Current Zoning: N1-B (neighborhood 1-B), N2-B (neighborhood 2-B)
Proposed Zoning: N1-B(CD) (neighborhood 1-B, conditional), N2-B(CD) (neighborhood 2-B, conditional), and CG(CD) (general commercial, conditional)

Approximately 80 acres located on the east side of East Independence Boulevard, north of Hayden Way, and west of Sam Newell Road.

The petition proposes to allow all uses permitted by right and under prescribed conditions in the N1-B, N2-B, and CG zoning districts, and to provide for commitments related to Irvins Creek Greenway and the East/West Connector on acreage largely vacant save for a single-family home built in 1928.

Staff recommends approval of this petition upon resolution of outstanding issues related to environment and transportation.

**RZP-2023-069
 REZONING**

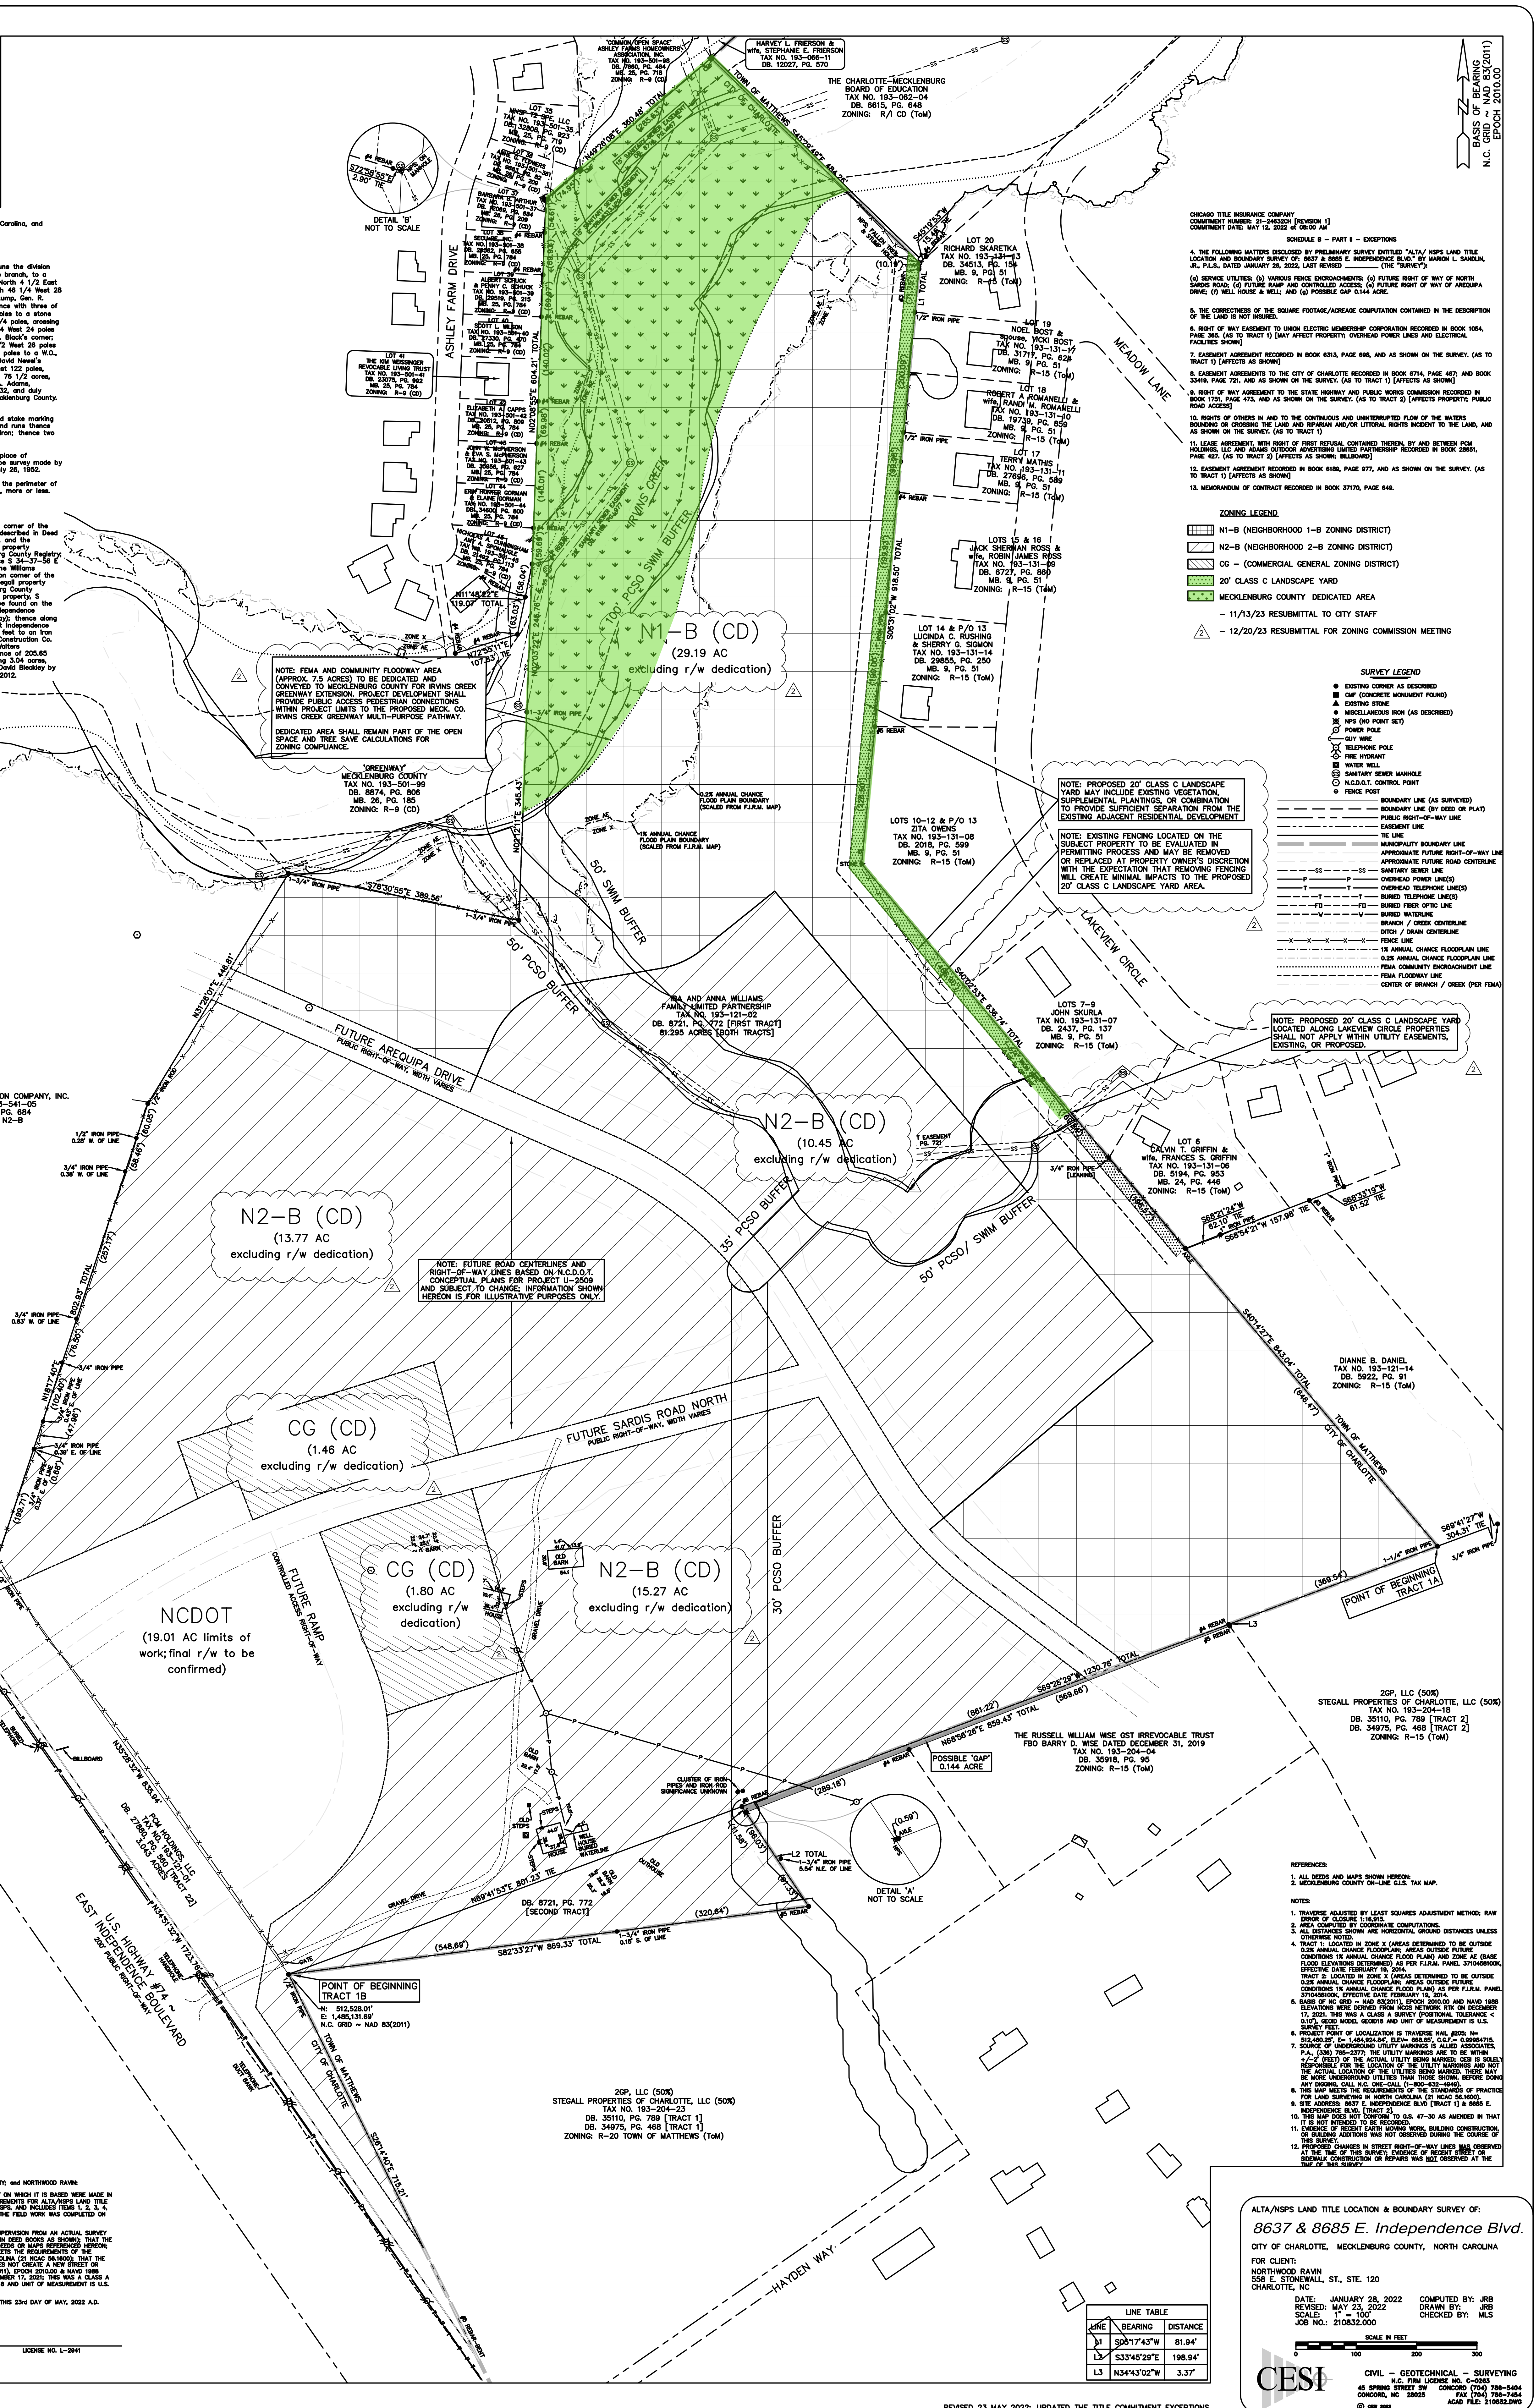
10. **New Comment 12/27/23** – Add a development condition to reserve right-of-way for all four legs of the Future Sardis Road North/Arequipa Drive extension. Currently, the plans reserve ROW for three of four legs. Right-of-way reservation areas for all future streets should be located according to the CDOT Streets Map and NCDOT TIP project plans.

1. MCPR requests minimum of 3.5 acres to be dedicated and conveyed to Mecklenburg County for a future local park. This requested park land shall be adjacent to a public right-of-way for access and is conducive for the development of the typical amenities found in a local park and cannot include tree save parcels or stormwater BMP's. Ideally, the proposed park land shall be adjacent to the requested greenway access easement.
2. The dedication note should read: "...to be dedicated and conveyed to Mecklenburg County for Irvins Creek Greenway..." Easements are conveyed to Mecklenburg County, not to the Park and Recreation Department. The creek is Irvins Creek, not Irwin Creek.
3. The notes should be revised to reference "Irvins" Creek.
